From: Simon Davis
Sent: 17 May 2021 11:07
To: 'Daniel OShea' [REDACTED]
Subject: RE: Summer Lane Pagham - P/69/21/CLP

Simon J Davis MRTPI
Principal Planning Officer
Directorate of Place

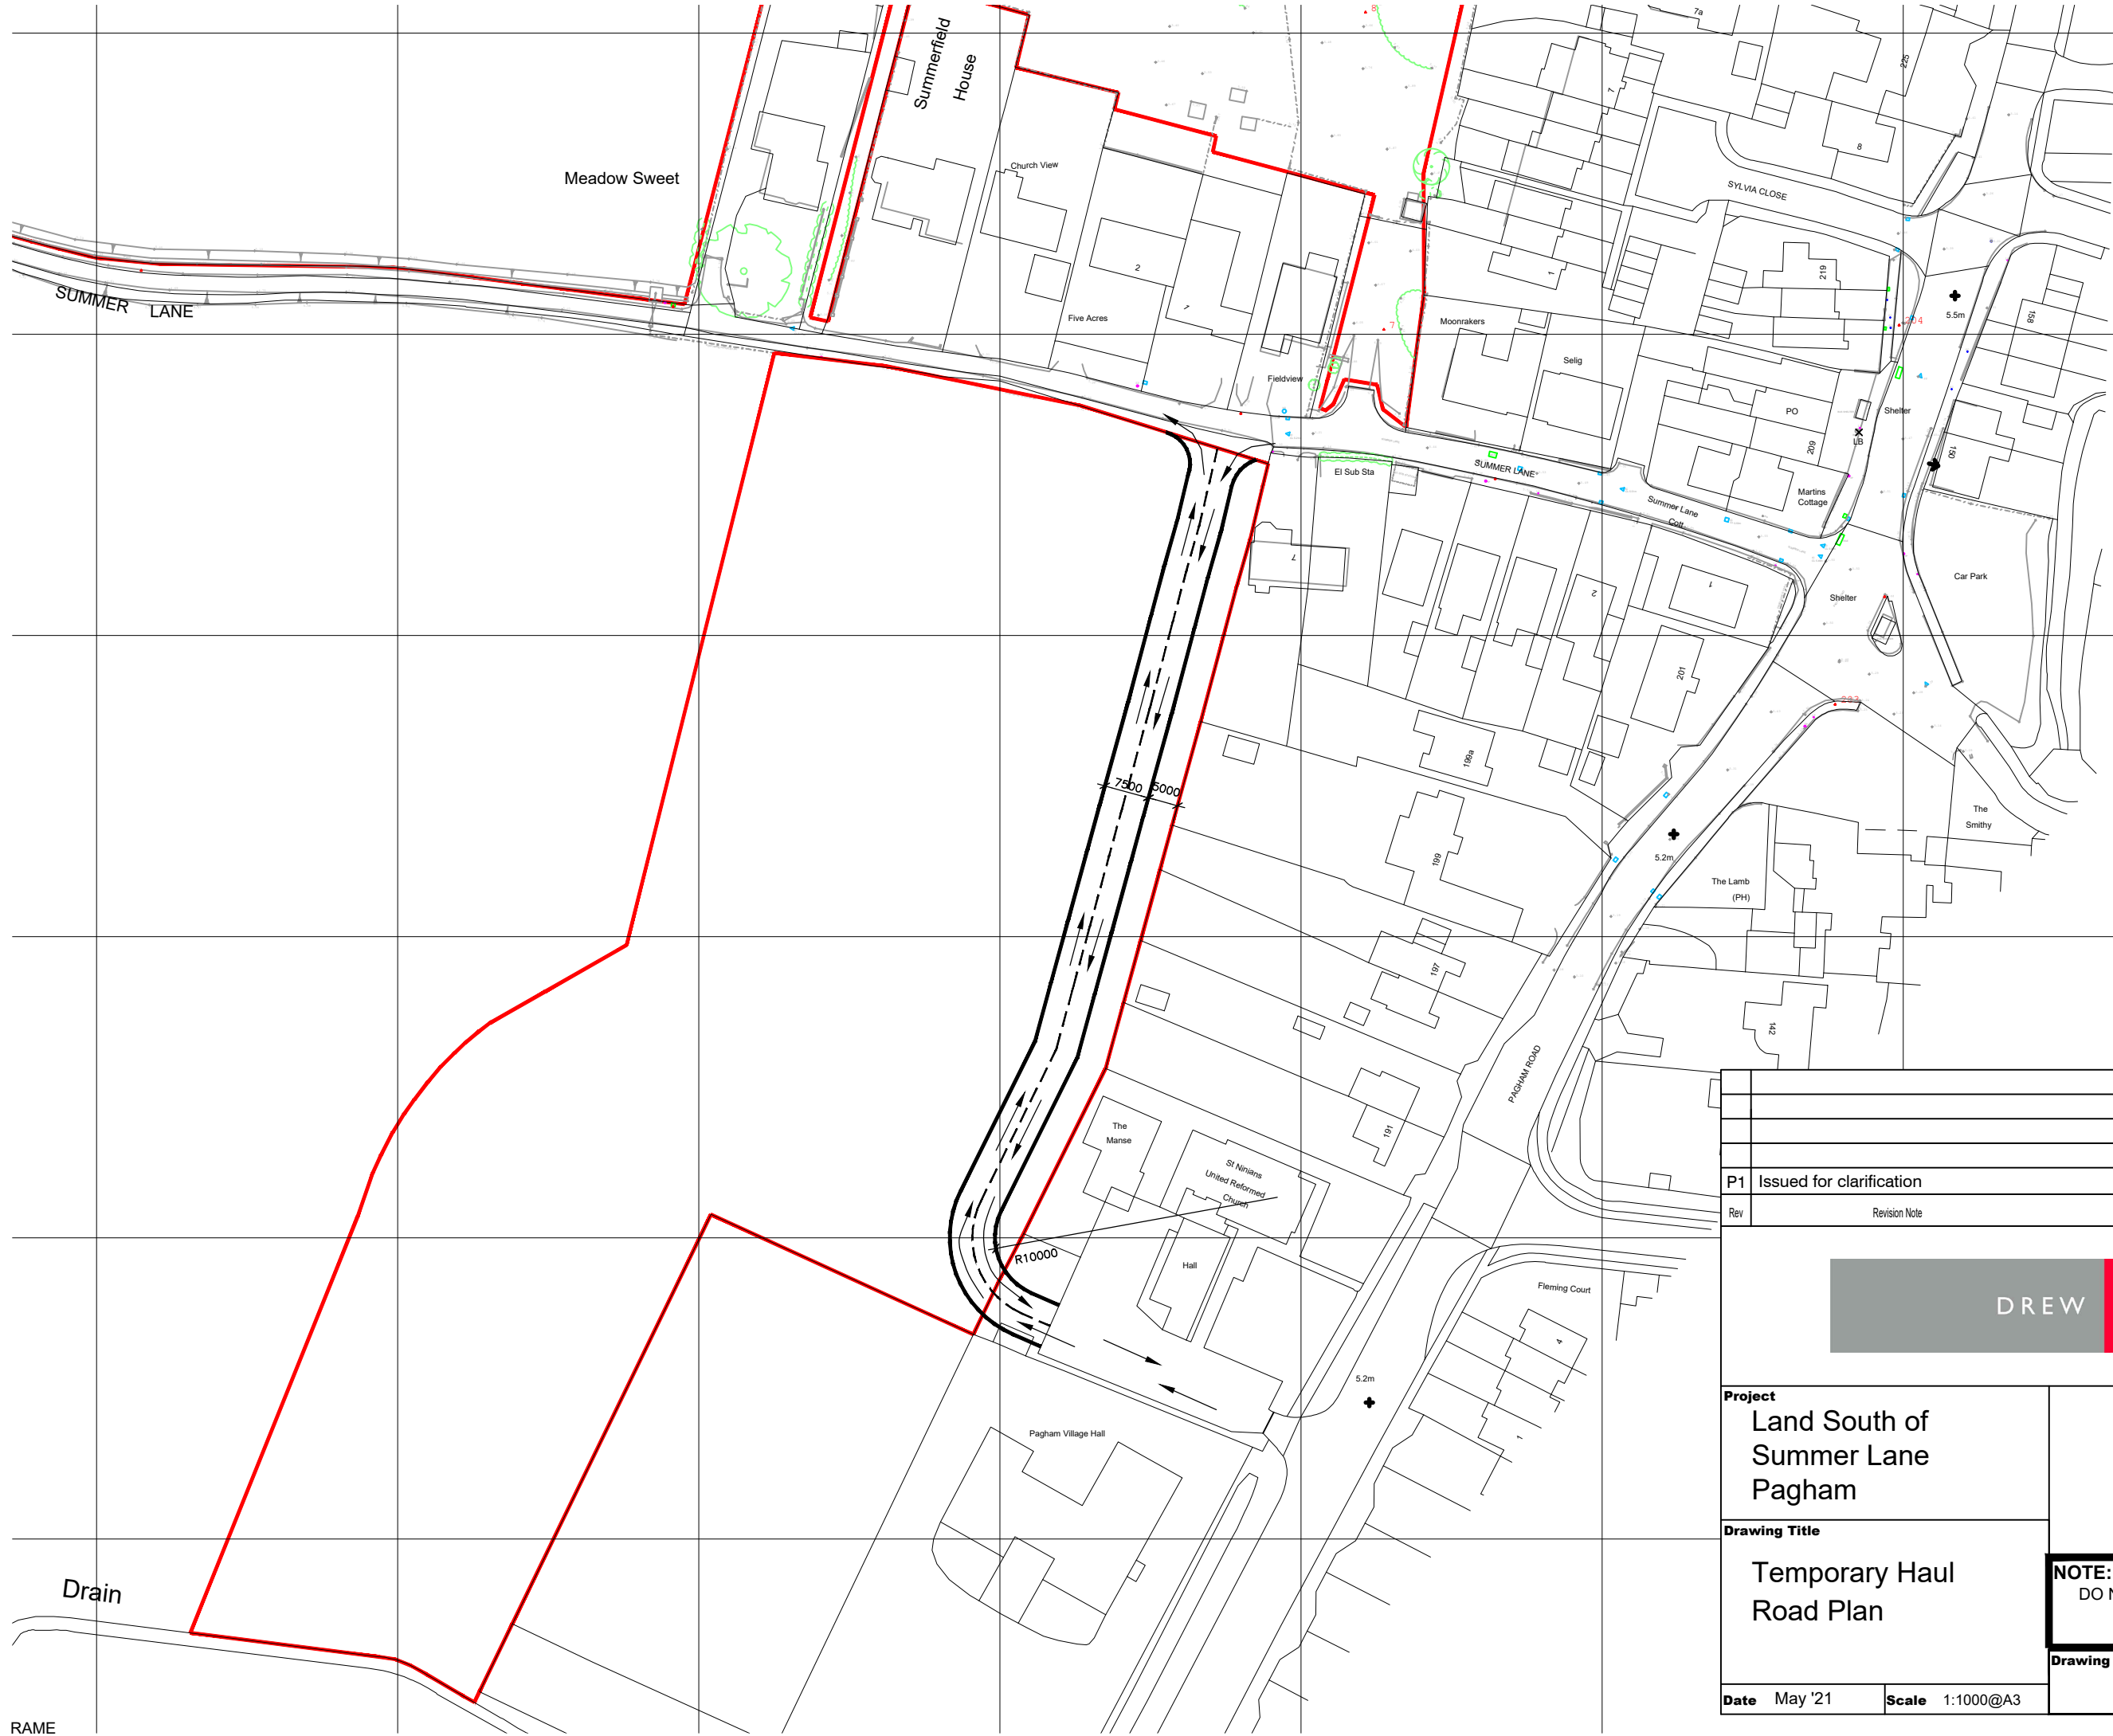
Further to the below, I had a conversation with our Legal Service Manager this morning. She is advising that you either specify on a plan the exact line of the haul road or at least indicate how far from the eastern boundary it will be and how wide it will be. That way, we can be sure of what is proposed. Please do also respond to the points below.

Thanks for your email. I have had a call from a resident of Pagham Road this morning. The person accepted the reason for the road but wanted to know what the road surface will be, whether it will be one or two way, what will the exact line of the road be/how far will it be from fences and how long will it be required for? Are you able to provide some of this information so that I can relay it to residents.
